Transport
for NSW

TfNSW Reference: SYD20/01234/02

DPIE Reference: SSD-10272349

EXHIBITION OF EIS - YIRIBANA LOGISTICS ESTATE - KEMPS CREEK

FUNCTIONAL LAYOUT PLAN
SCALE 1:250

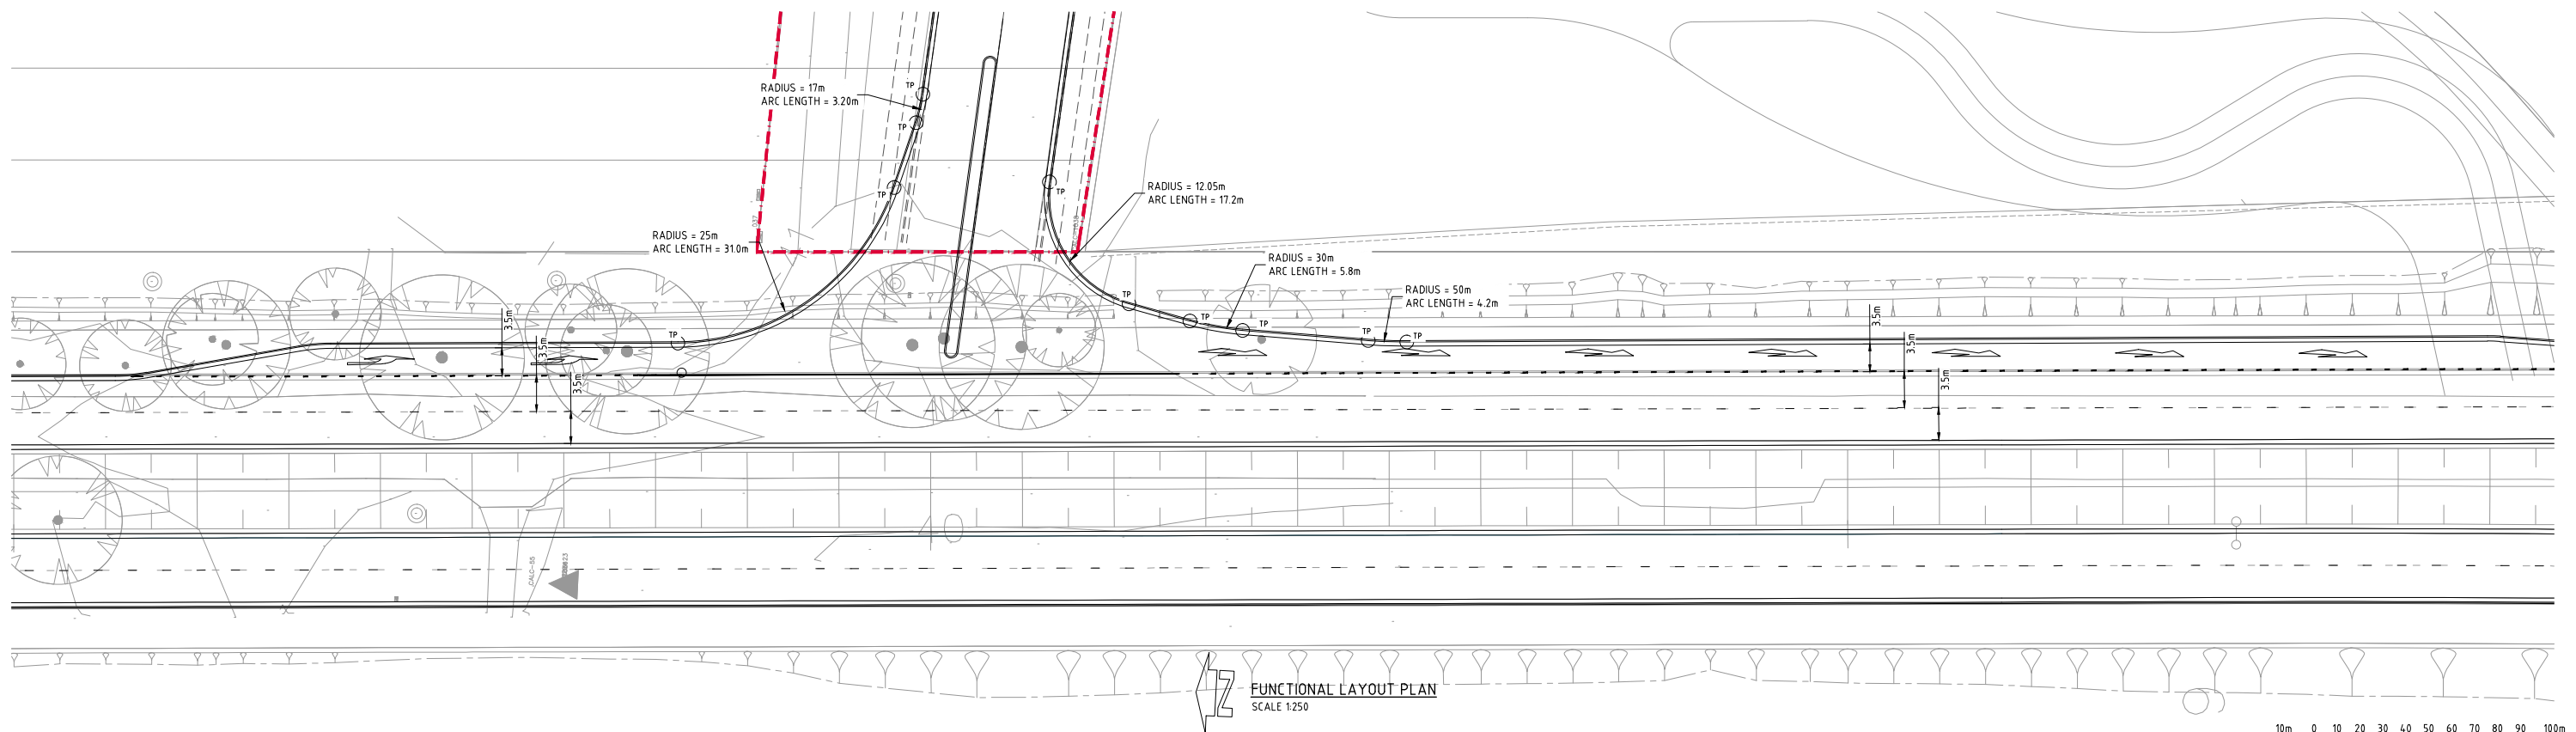
- a. The proposed intersection extends across the frontage of the adjacent properties. Should Mamre Road be upgraded prior to the local road connection this access will likely require further land acquisition from the affected properties. How will the applicant ensure that the relocation and reconstruction of the deceleration/acceleration lane can be achieved within the adjoining property boundaries in the event that Mamre Road is upgraded prior to the removal of this access? Has consultation been undertaken with the affected land owners? The land required for this relocation should be at no cost to TfNSW.

- b. The applicant is to dedicate 3.5 m wide land (from the edge of the road reserve) for the full length of the deceleration.
- c. What is proposed to prevent right turning movements at this access? The intersection is to be designed to be physically restricted to LILO.

- d. What is the proposed alternate route for vehicles seeking to turn right in or right out?
- e. Deceleration lane does not appear to meet Austroads requirements for 80km/h design speed (and design speed of 5km/h for curve/turn). The intersection is to be designed in line with Austroads Standards.

- f. Acceleration lane does not appear to meet Austroads requirements for 80km/h design speed (and design speed of 5km/h for curve/turn). The intersection is to be designed in line with Austroads Standards.

TfNSW requests the abovementioned information to be addressed/provided for further assessment prior to the determination of the application. TfNSW will further review and provide response upon receipt of the additional information.
